Architectural Design
Saxon End
Bordean
Petersfield
GU32 1EP

Please ask for: Sian Eggington
Email: sian.eggington@terraquest.co.uk
Telephone: 0121 2341390
Our Ref: AL/57/21/HH
Your Ref:
Date: 20th May 2021

Application for Planning Permission for Works or Extension to a Dwelling

Development: Erection of single storey front and rear extension and two storey side extension following the demolition of existing single storey side extension
Location: 31 Barnett Close Westergate Aldingbourne PO20 3UW

© Copyright ALL DIMENSIONS TO BE CHECKED ON SITE Scale 1/100 Date April 21 Drg. No. GO/21/006	Drawing Title Proposed Elevations	ARCHITECTURAL DESIGN  Saxon End Bordean Petersfield Hampshire GU32 1EP
	Client Mr S Goring 31 Barnett Close, Eastergate

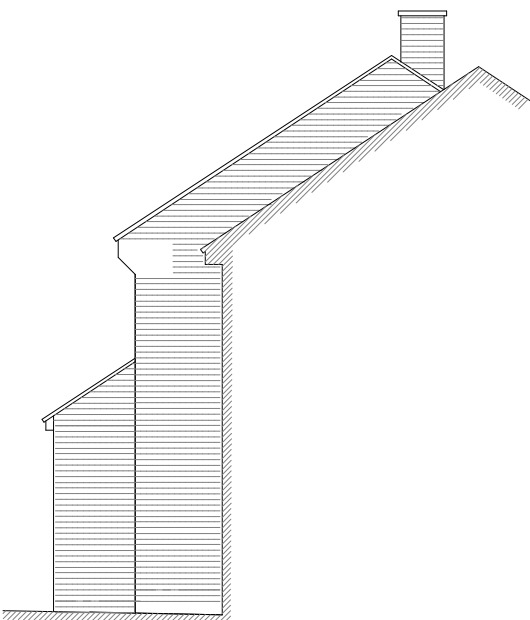
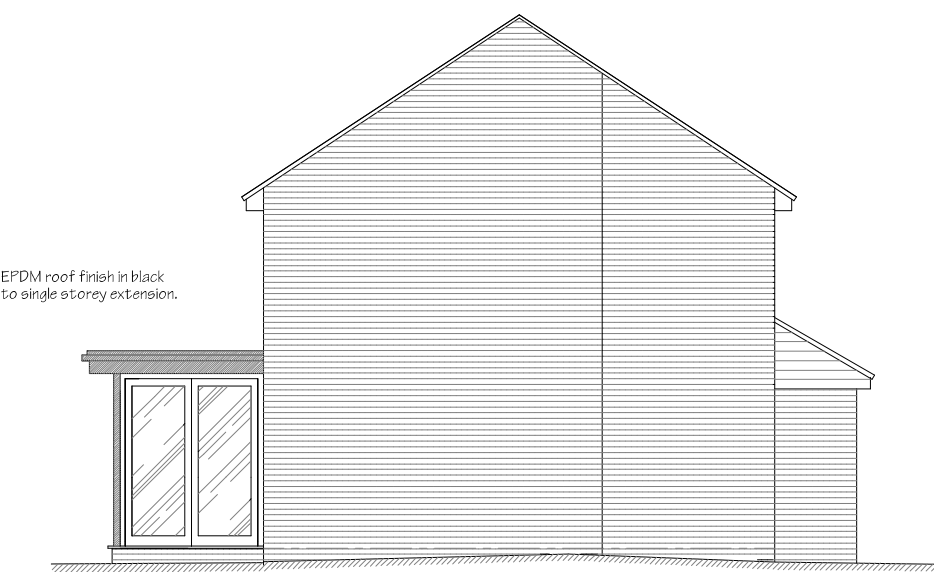
Please submit the existing and proposed other side elevation at a scale of 1:50 or 1:100. Further details can be found in the Validation Requirements List.
